# CITY OF ALBUQUERQUE

**RE: Kinesio Headquarters  
Grading and Drainage Plan  
Engineer's Stamp Date 11-30-2015 (File: D17D103)**

## ROOF DRAIN OUTLET CHANNEL:

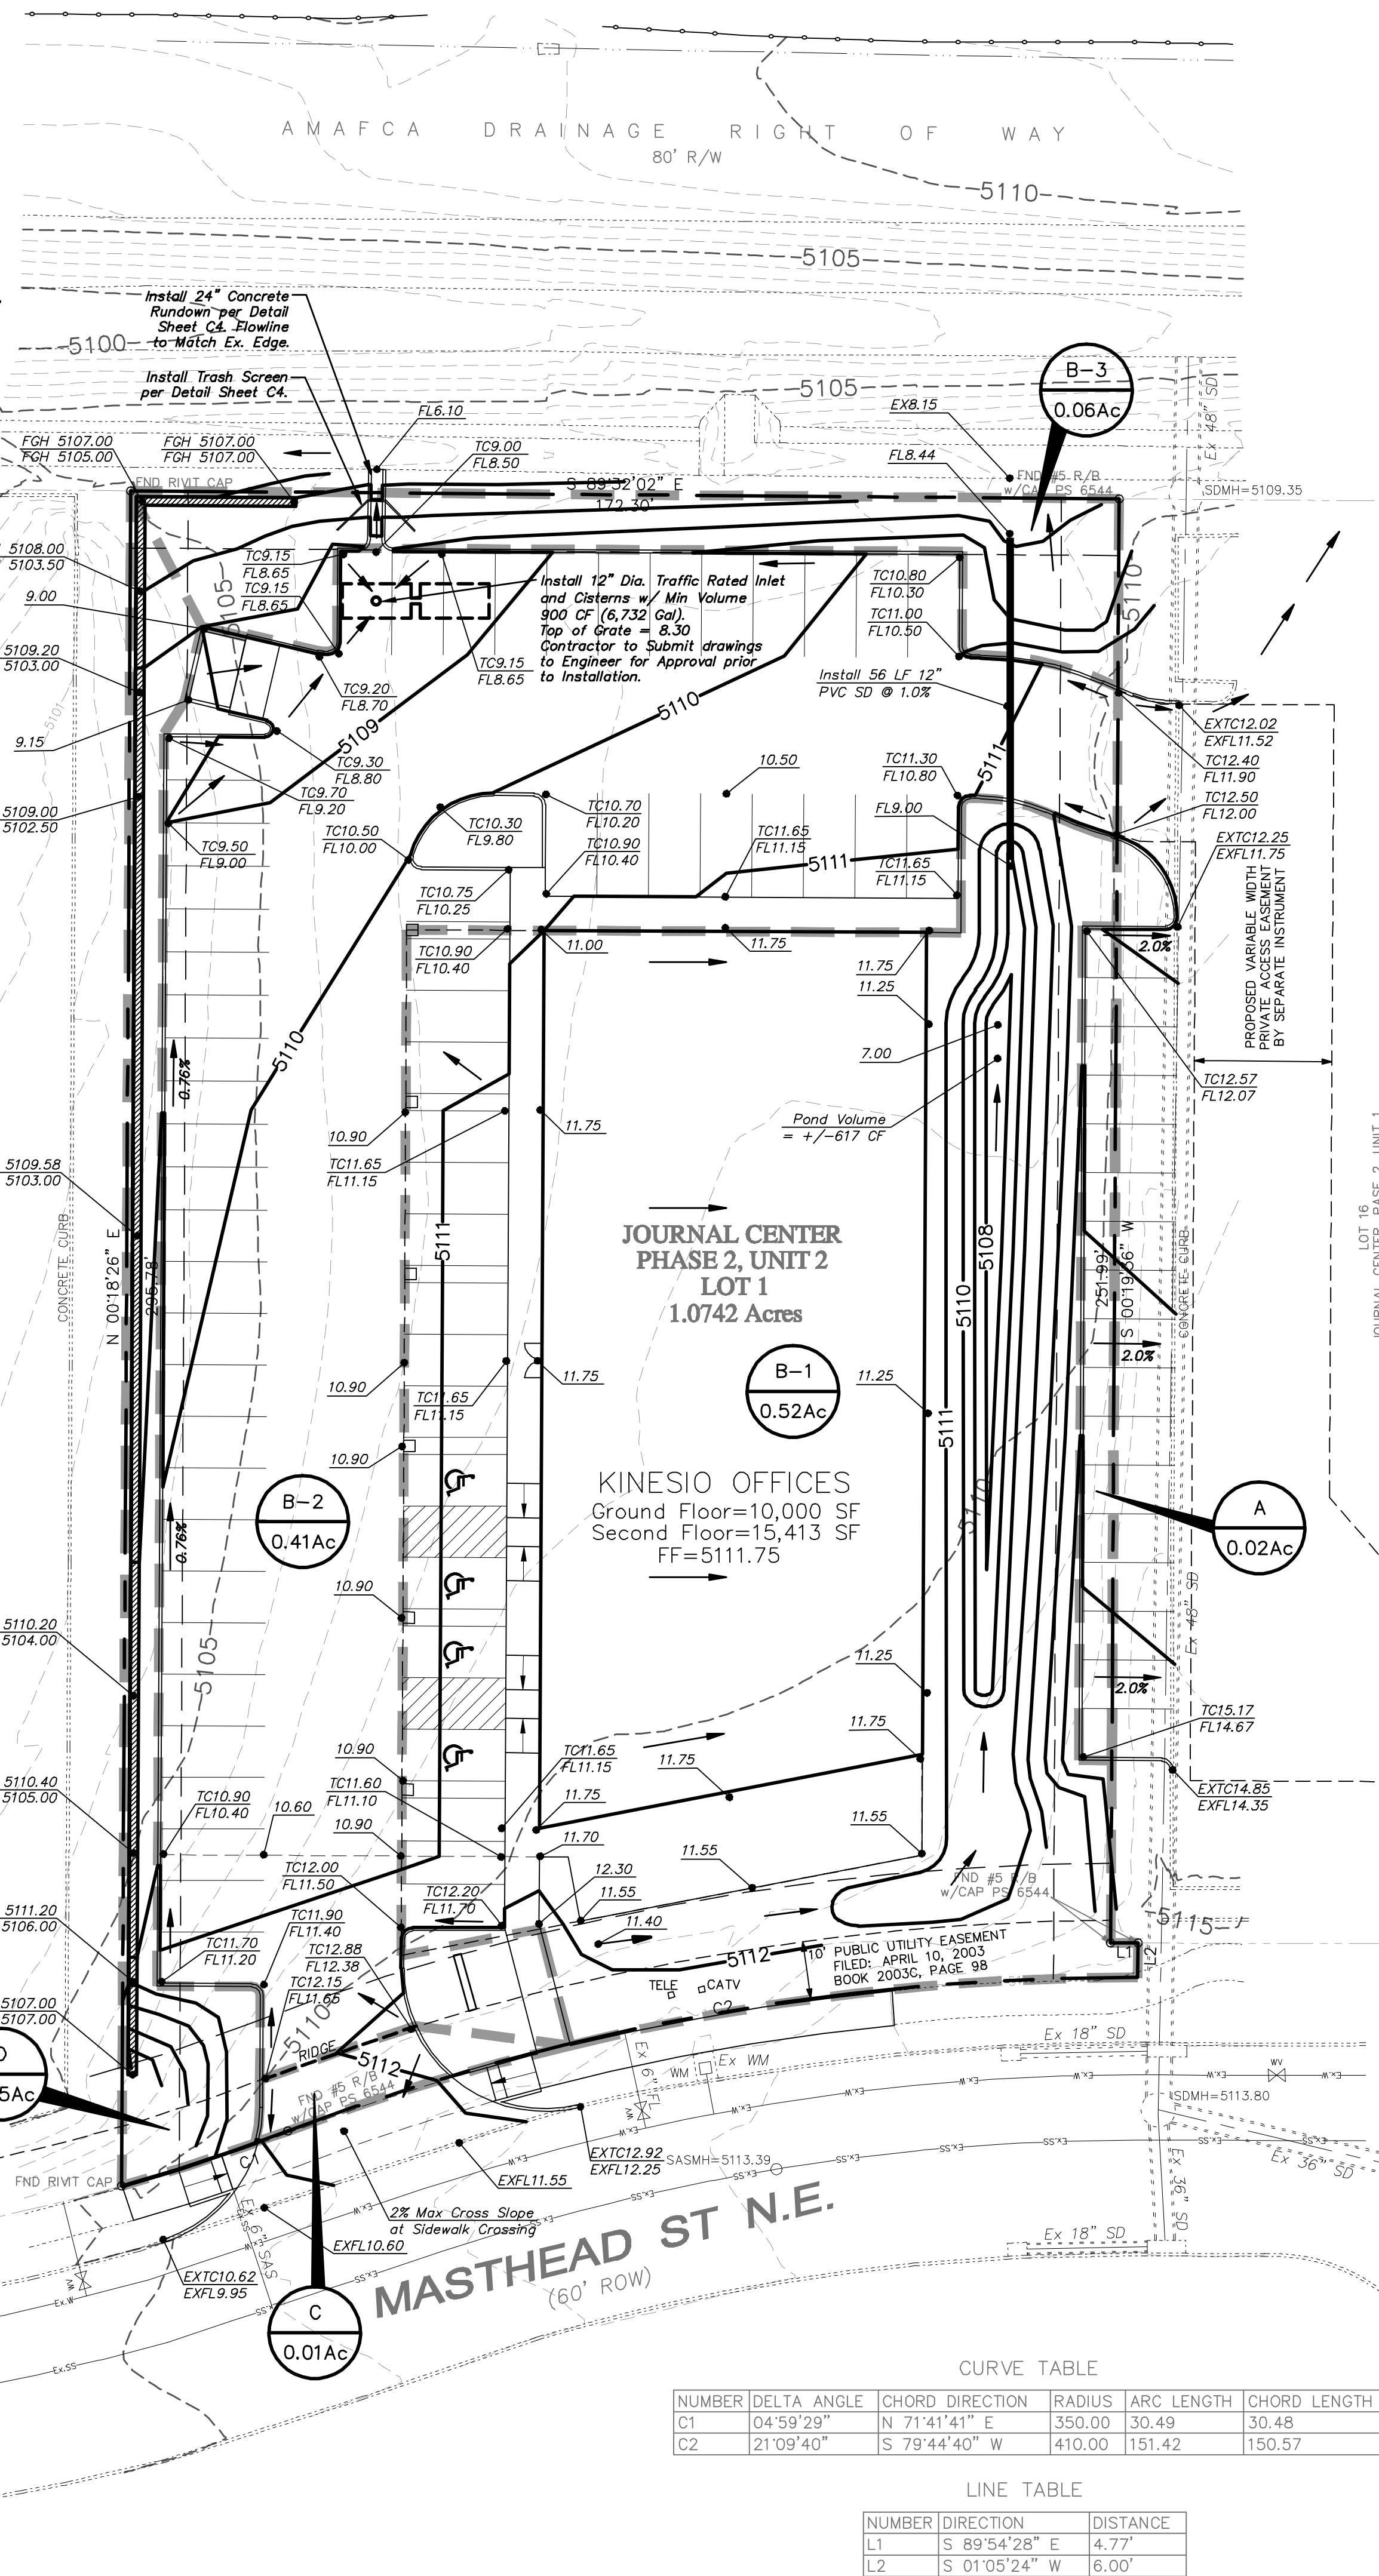
2. Provide a capacity vs required flow calculation for the rundown just downstream of the last roof drain to show that the peak flow is contained in the structure.

GRADING AND DRAINAGE PLAN

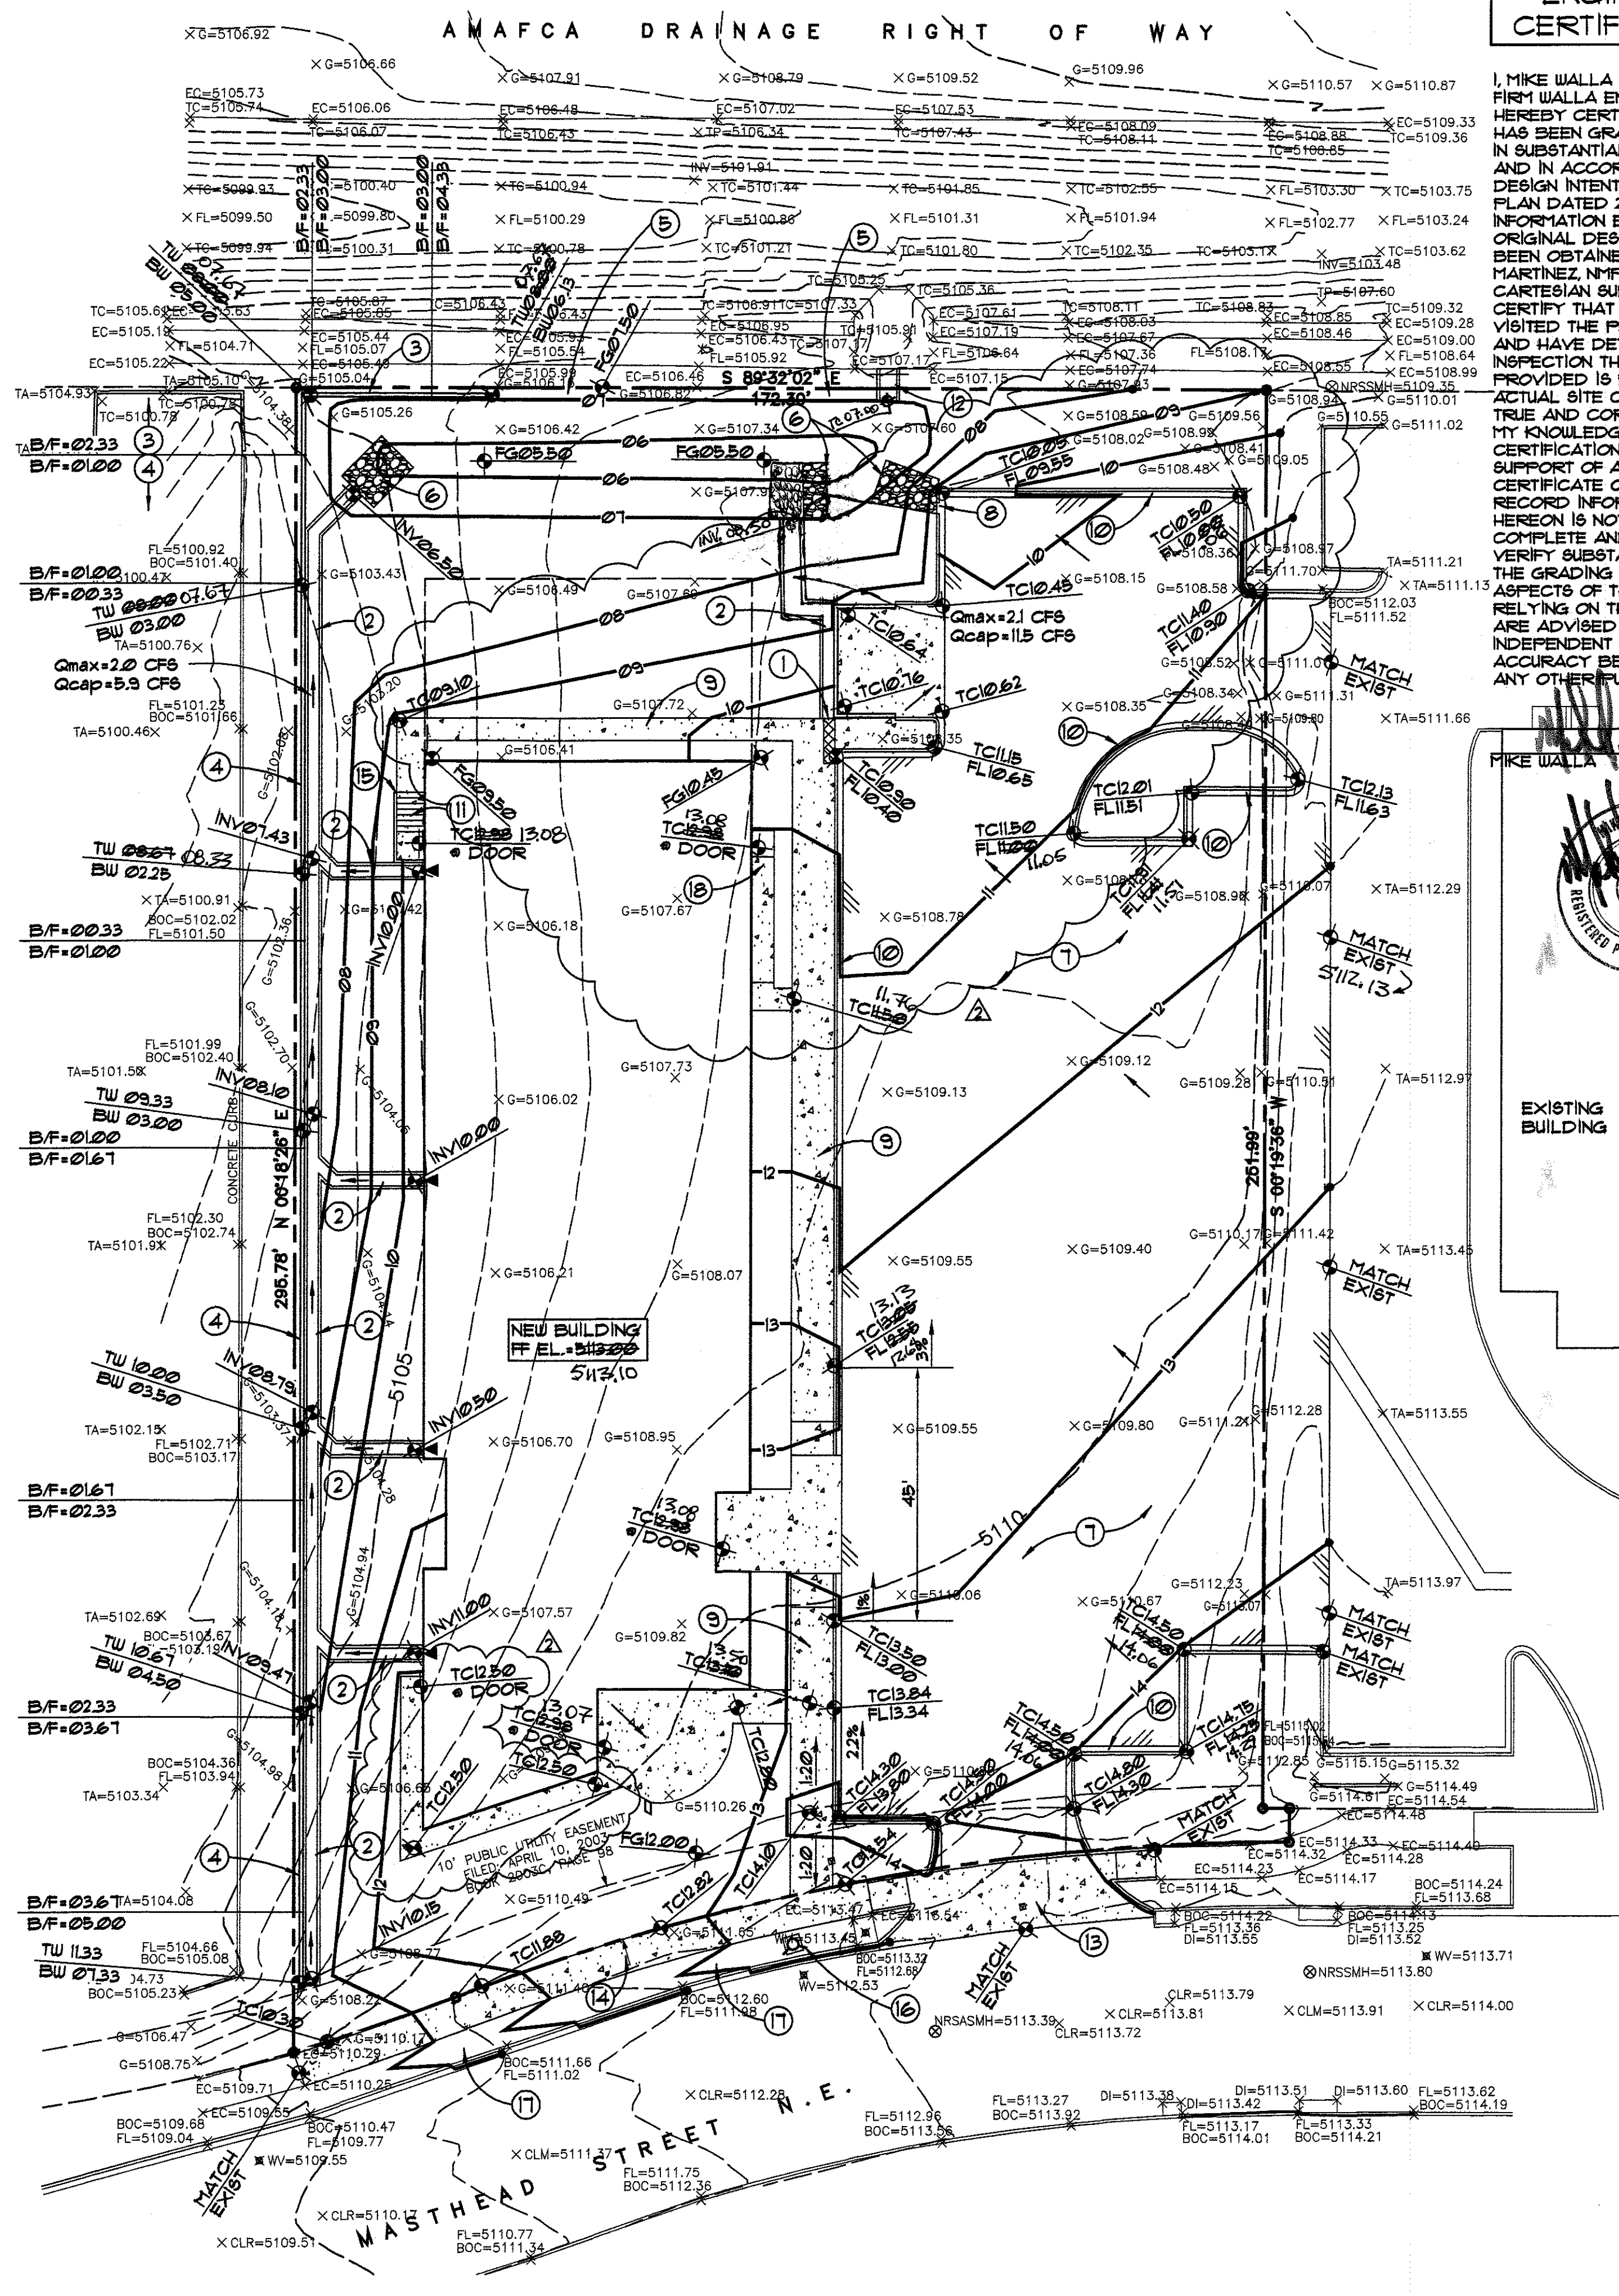
1. We understand that the license agreement with AMAFCA is in progress for the drainage outlet onto their Right of Way. Concurrence that the license agreement is completed (or that it will be completed) will be needed. Provide a calculation of the capacity of the outlet opening/structure to show that the peak flow of the pond is controlled.

3. Beginning January 15<sup>th</sup>, 2016, the City will amend the standard city street section (std drawing 2405A and B) to include a depressed landscape buffer between the sidewalk and back of curb. We request that you consider implementing this detail for the landscape buffer on the Masthead Street frontage.
